ESSENDON PARISH COUNCIL

24 August 2022

Comment on Planning Application: 6/2022/1610/HOUSE

53 High Road Dropped Kerb Extension

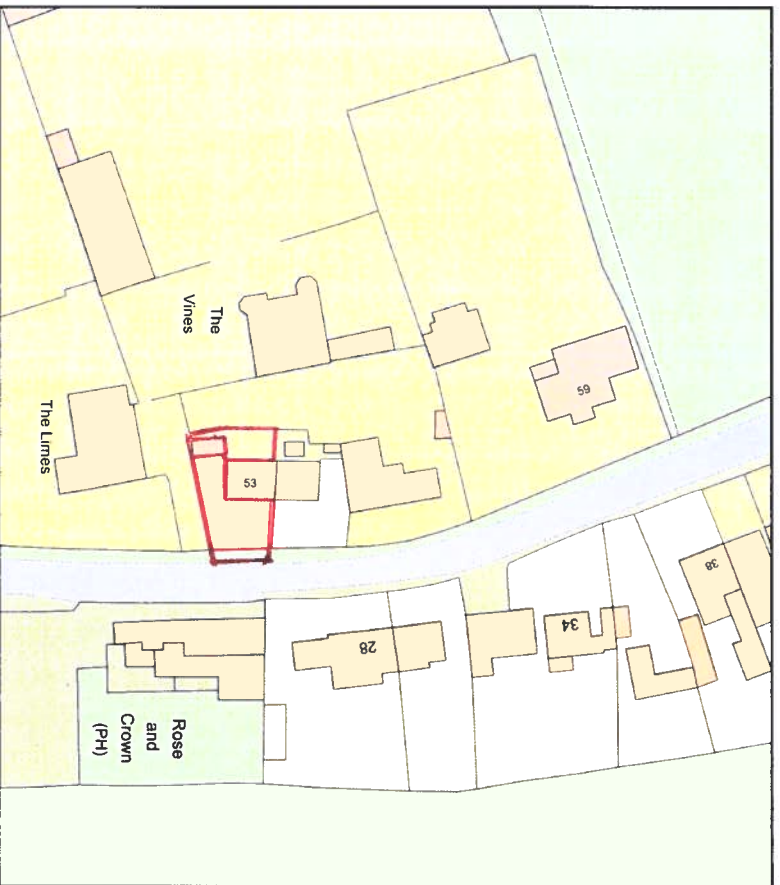
Essendon Parish Council continues to object to this proposed extension of the dropped kerb to this property. The purpose is clearly to facilitate the parking of further cars on this frontage which will harm the character and appearance of the Conservation Area. Comments by the Conservation Officer under the two previous applications on the importance of retaining hedging and introducing 'meaningful' planting have not been addressed under this new application.

In terms of public safety, we note that the Highways Authority have now recognised that the existing dropped kerb is the maximum size allowed and that, as cars cannot turn around within the front garden, cars will have to reverse onto the busy High Road which is dangerous and contrary to current policy.
